SSD-6693 MODIFICATION – PROPOSED RYE PARK WIND FARM

I refer to your correspondence regarding the subject Application which was referred to Transport for NSW (TfNSW), formerly Roads and Maritime Services, for assessment and comment.

The application for modification of the proposal is supported by Rye Park Wind Farm Modification application Report dated April 2020 prepared by Tilt Renewables and Traffic Impact Assessment (TIA) prepared by SMEC dated April 2020. From the information provided it is understood the proposed modifications being as part of the application to modify include:

Figure 6 | Approved and Proposed Over-Dimensional and Heavy Vehicles Access Route

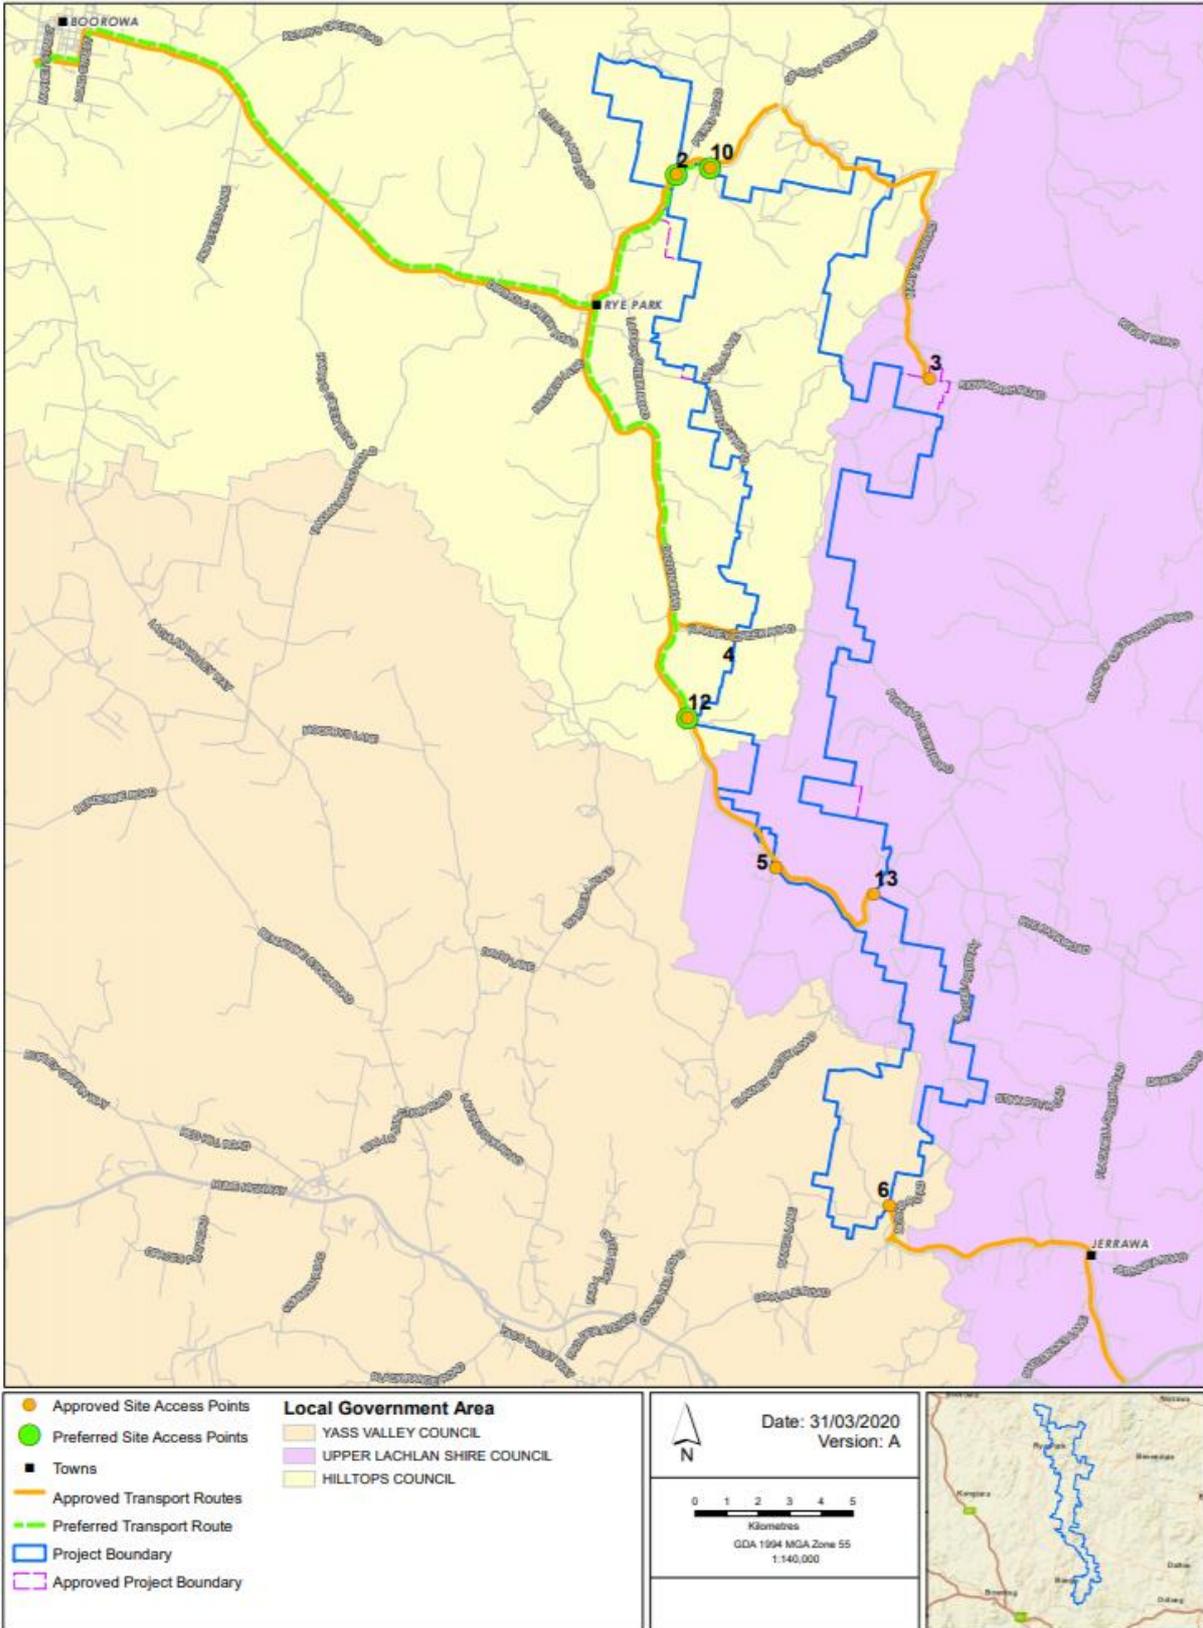
The submitted documentation identifies and documents the preferred route for the transportation of the large components on the road network to the development site from Boorowa via Rye Park Road. However the submitted documentation does not appear to include a full assessment of the impact of the transportation route along the classified road network, particularly the Lachlan Valley Way, to travel from the Ports to Boorowa.

The documentation submitted with the previous referrals identified the proposed haulage route for the components of the wind turbines and ancillary structures as being along the Hume Highway exiting the highway at its intersection with Jerrawa Road and the western intersection with the Yass Valley Way. A secondary route via the Hume Highway onto the Lachlan Valley Way was also identified. The revised proposal now appears to endorse the use of Lachlan Valley Way as the primary route.

Previously the approved over-dimensional route was from Port Kembla to the site via the Hume Highway and Lachlan Valley highway. The proposed modification introduces the potential for the haulage of the various components from the Port of Newcastle. The TIA identifies that the delivery of turbine components has been considered from two ports, Port Kembla and the Port of Newcastle. However the TIA indicates that the route(s) will be finalised subject to the selection of a final turbine and contract award. The TIA also indicates that an alternative route from the Port of Newcastle via Dubbo is also being considered. TfNSW notes that at this stage the final route is still to be adopted.

1. A Traffic Management Plan shall be prepared in consultation with the relevant road authorities (Council and Roads and Maritime Services) to outline measures to manage traffic related issues associated with delivery and construction of the turbines or ancillary structures, any construction or excavated materials, any machinery and personnel involved in the construction or decommissioning process. The plan shall detail the potential impacts associated with the development, the measures to be implemented, and the procedures to monitor and ensure compliance. This plan shall address, but not necessarily be limited to;

- i) Details of traffic routes to be used by heavy vehicles associated with the project, and any associated impacts and any required changes to the existing road environment along the proposed routes such as intersection upgrade, road widening, temporary street closures, removal and replacement of road infrastructure, etc required in order for the necessary materials and machinery to be delivered to site.
